DOC17/242270
SSD 6456

Narrabri Gas Project (SSD 6456)

Thank you for your invitation for the Office of Environment Heritage (OEH) to comment on the exhibited Environment Assessment for the Narrabri Gas Project.

ATTACHMENT A**OEH Comments****Biodiversity**

Figure 15-1

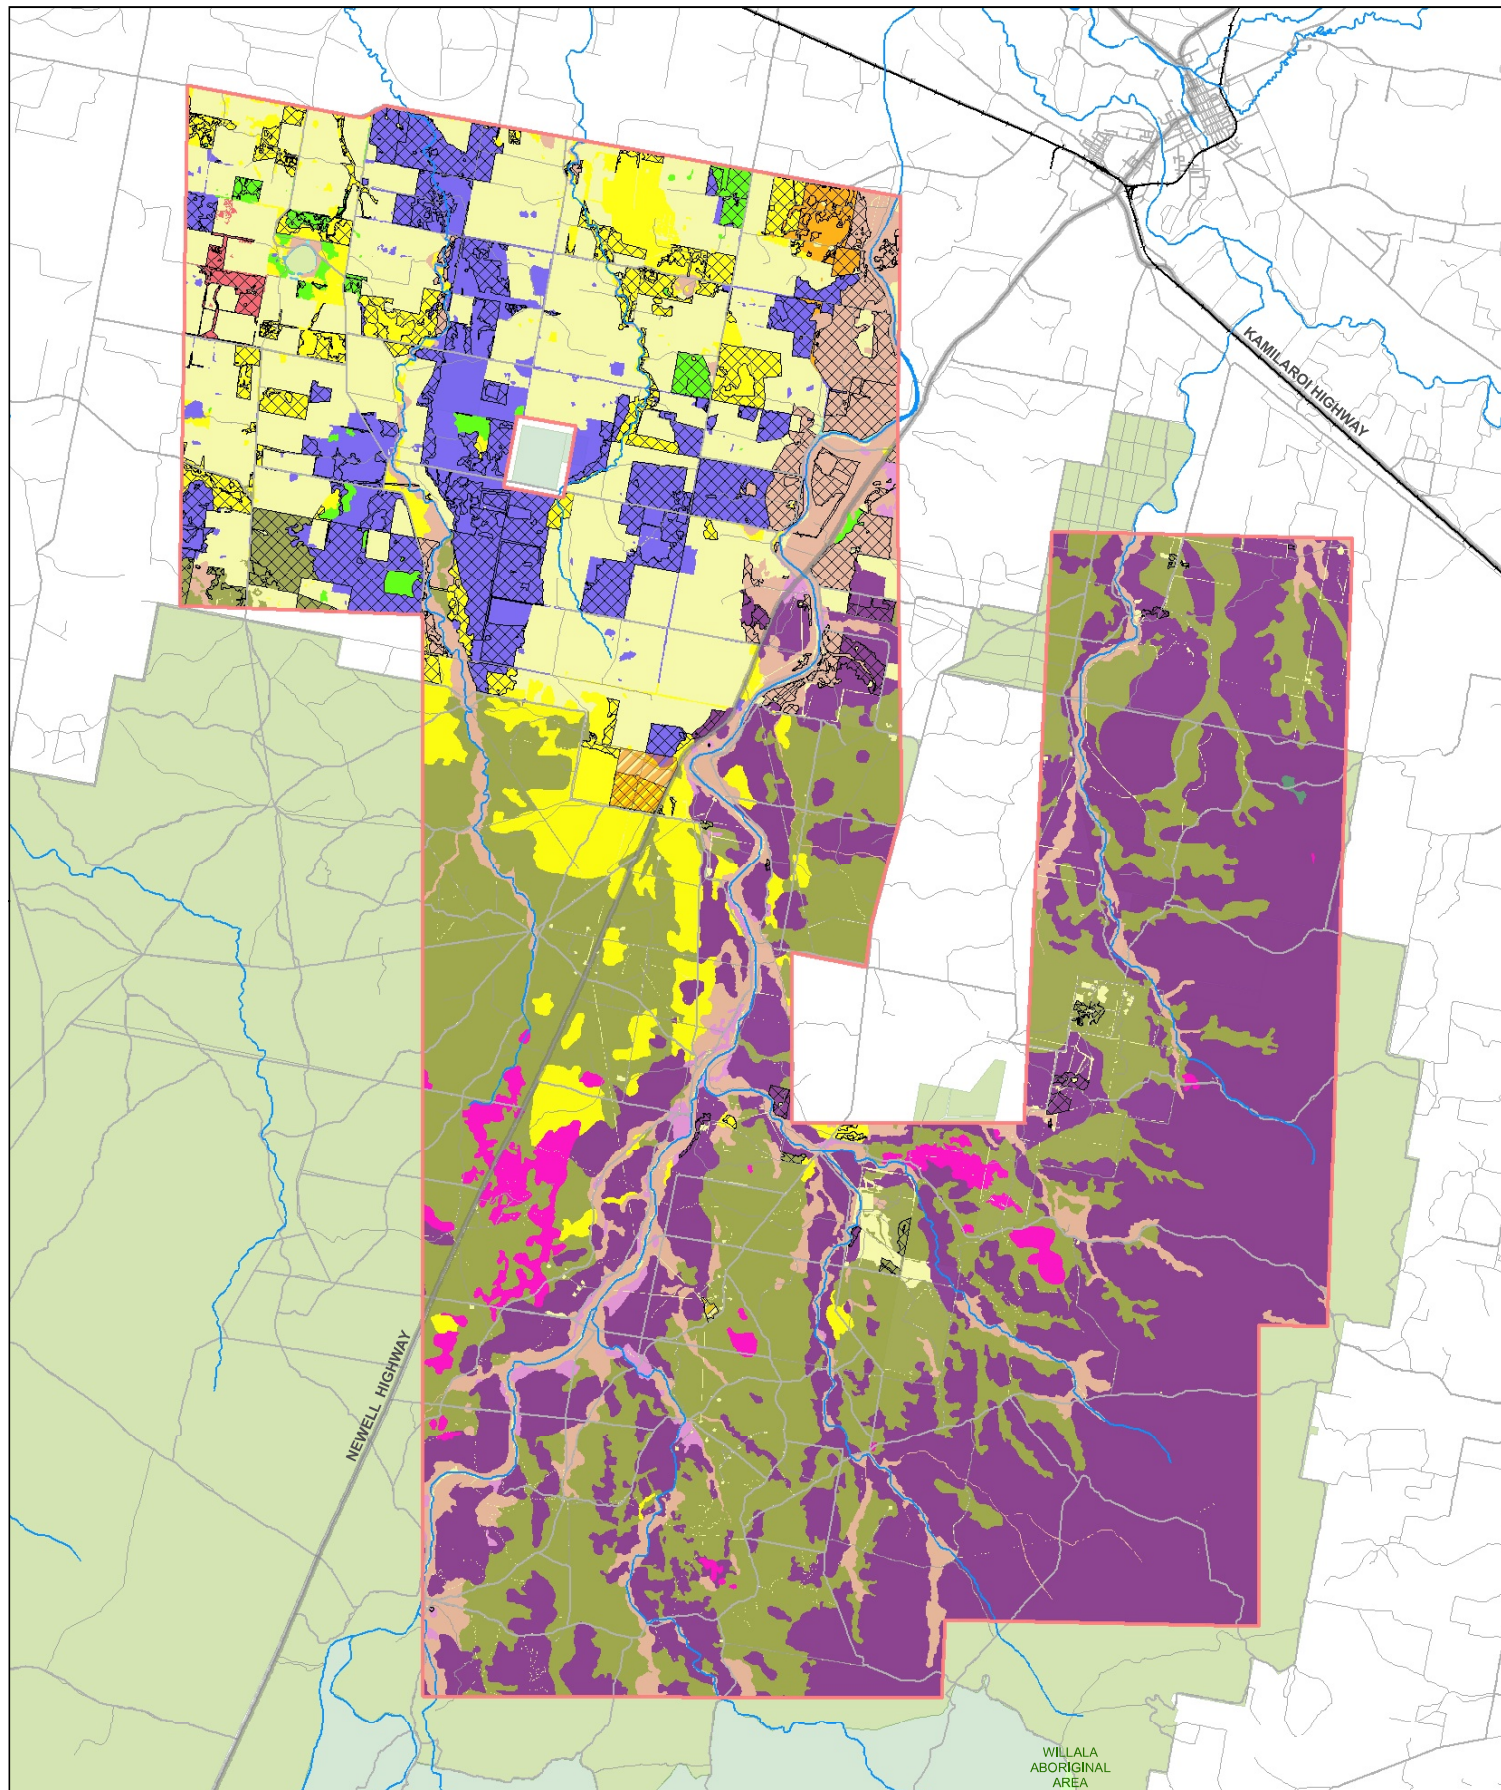
1. The vegetation map should be validated against all vegetation plot data.

The calculation of the upper disturbance limits depends upon the accuracy of the vegetation map produced for the project. The vegetation map was first produced using a desktop process and was followed by field data collection at 327 locations. The floristic data collected at 20 per cent of those locations was then compared to the PCT mapped at those locations. The floristic data collected did not match the vegetation map at 11% of the locations analysed. The PCTs at these sites were corrected by the proponent however it is unclear if the corrections were made to the biometric data set or if the vegetation map was revised, or both. Both should be undertaken. Based on this sample analysis, it is likely that 11% (n = 29) of the remaining plots (n = 262) are incorrectly mapped. In addition the Vegetation Mapping report (ELA 2015) identifies that accuracy of the vegetation map is likely to be lower in some parts of the study area.

OEH has reviewed the Plant Community Type (PCT) allocations for all plot data that contained cover-abundance scores (n = 220) and focused on those PCT allocations that seemed the least

appropriate. Analysis using the Vegetation Information System (VIS) indicated that a better PCT match may be available for at least 16 vegetation plots (Table 2). The vegetation map should be validated against all vegetation plot data to ensure that the vegetation map is as accurate as possible and that the subsequent upper disturbance limits have been calculated using the best available data.

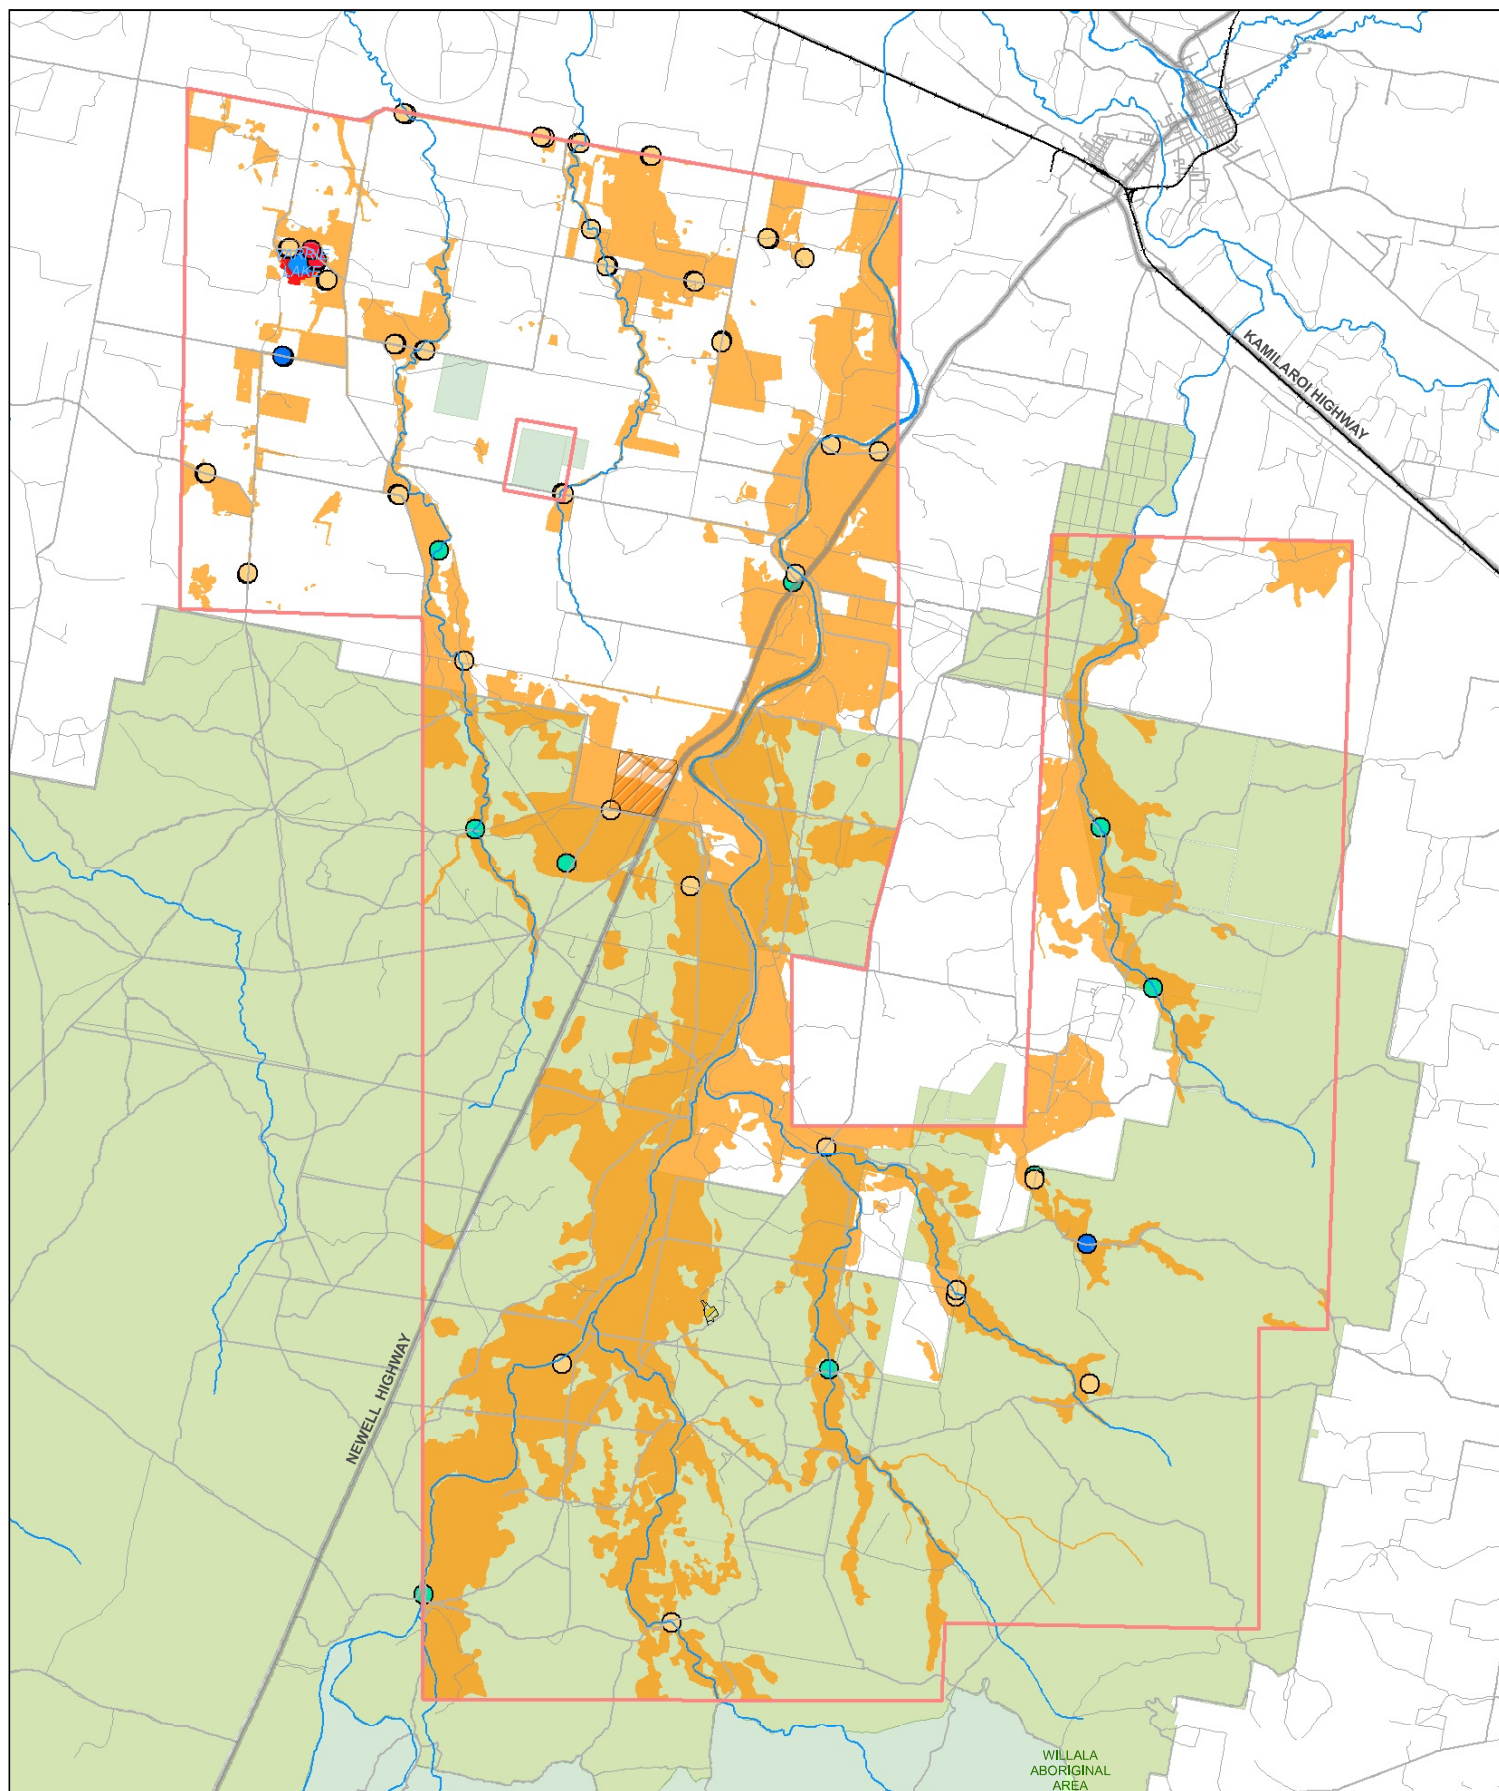
10. Either further assessment and credit calculation of the impact on the koala is undertaken or an expert report is required to assess the likelihood of occurrence of the koala in the study area.

Given the study area's position in the landscape (relative to known koala populations in the western Pilliga and around Gunnedah), the history of sightings (including three in 2016 on the NSW Atlas of Wildlife - entered post lodgement of the EIS) and the presence of suitable habitat, the study area provides some known, and potential habitat for the koala. Further assessment and credit calculation of the impact on the koala is required.

Alternatively the proponent may prepare an expert report to assess the likelihood of occurrence of the koala in the study area.

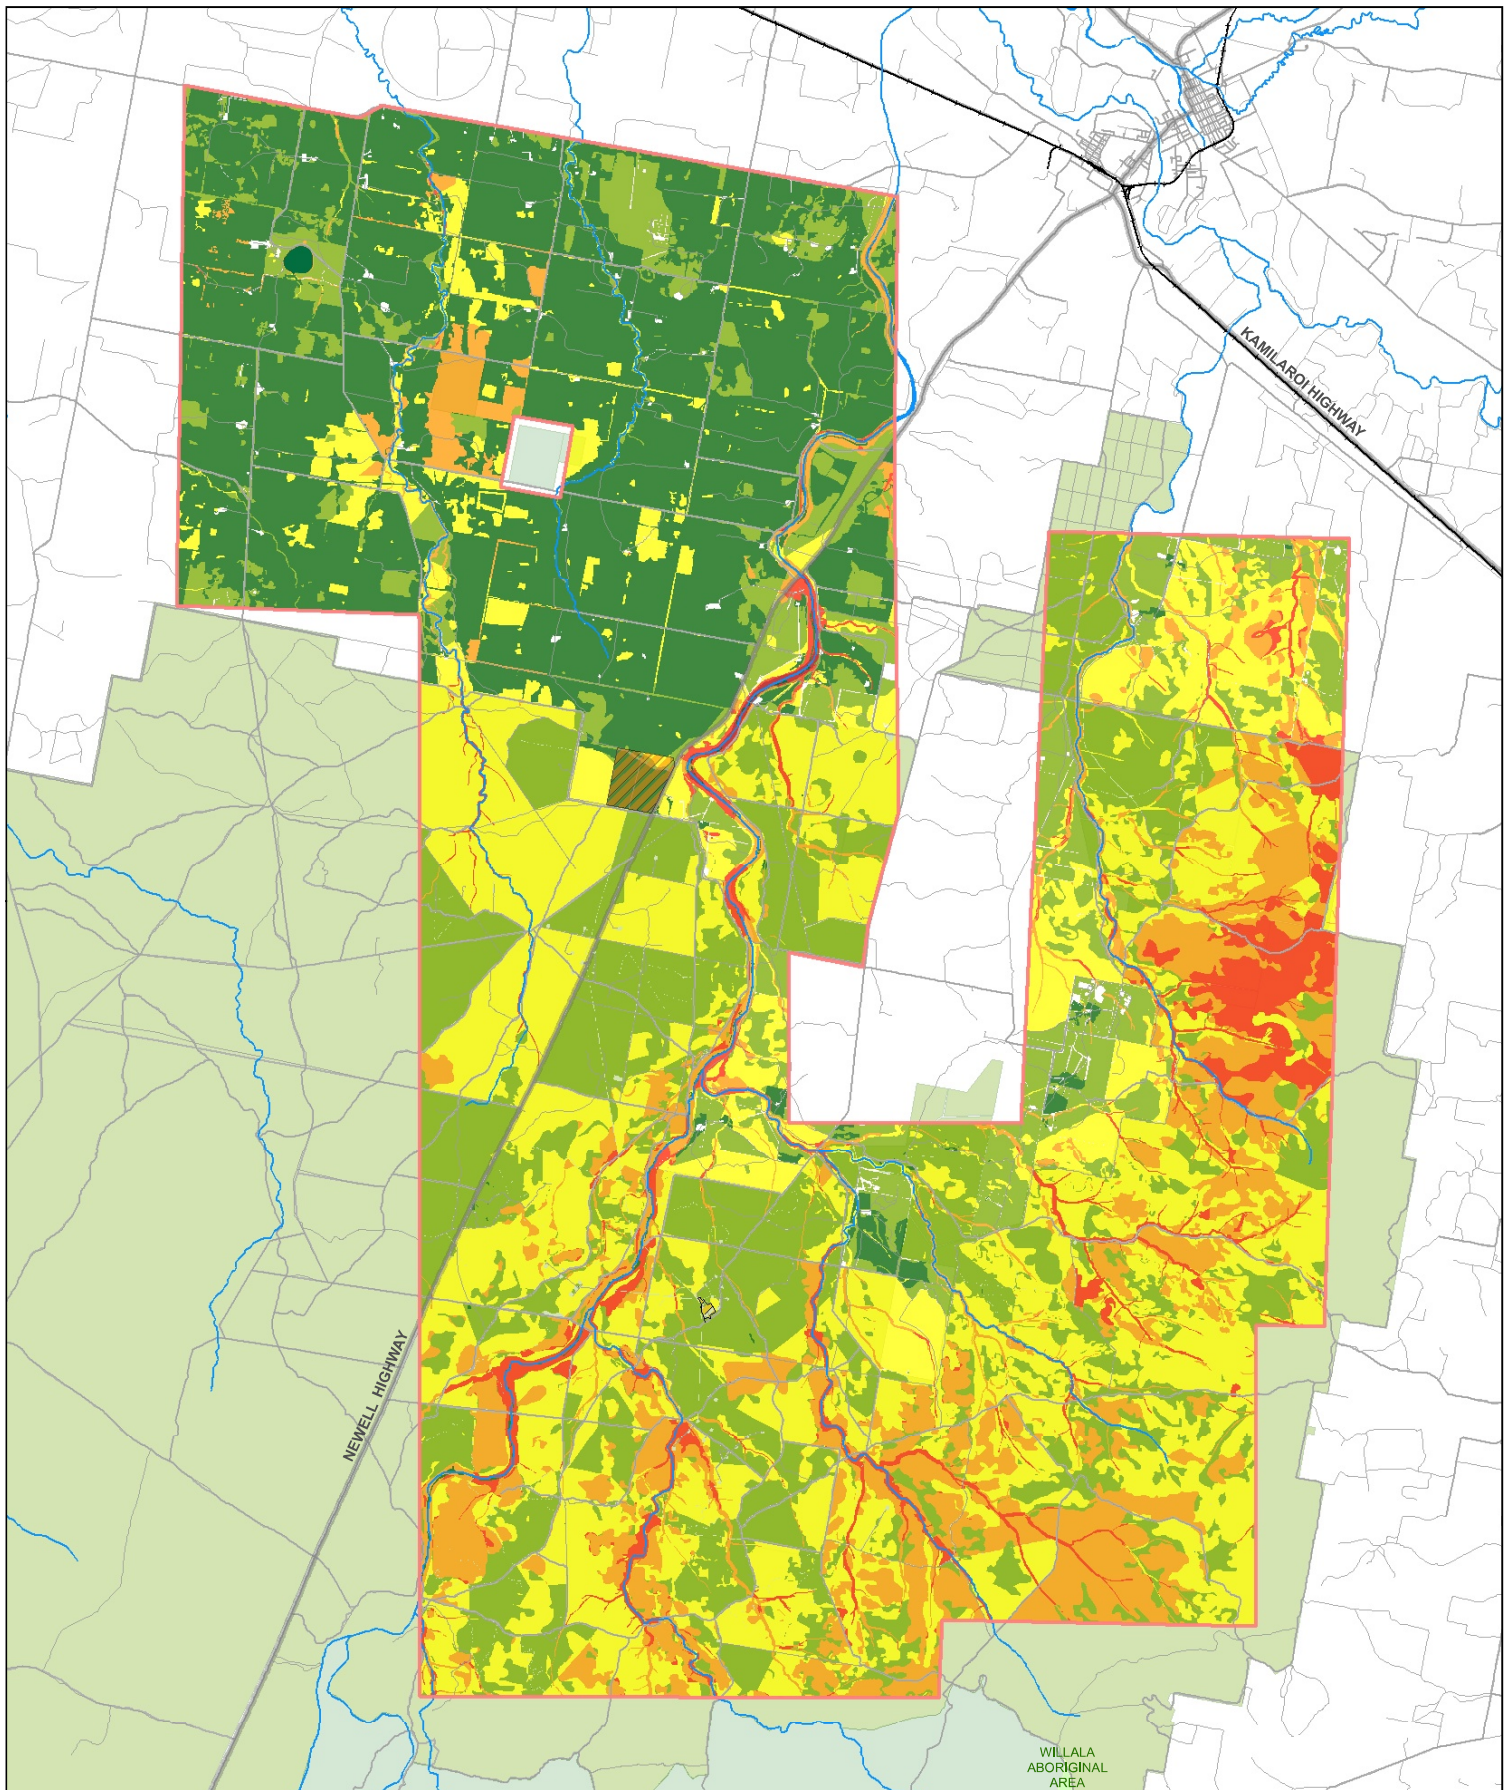
2. The rankings and weightings of the ESA should be reviewed and the ESA should be re-run.

The ESA has been used to guide avoidance of 'high' or 'moderate-high' ecological sensitive areas wherever possible with the relocation of infrastructure to 'low-moderate' or 'low' areas wherever possible. The ESA has also been used in the calculation of the upper disturbance limits.

The ESA report indicates that the decision criteria that underpins the ESA were identified through an internal workshop of EcoLogical Australia Pty Ltd ecologists and conservation planners. OEH has concerns with the rankings and weightings to some of the decision criteria.

OEH suggests that the rankings of all decision criteria are reviewed and a weighting reflecting the ranking is applied. OEH's recommended rankings and weightings are listed in Table 3.
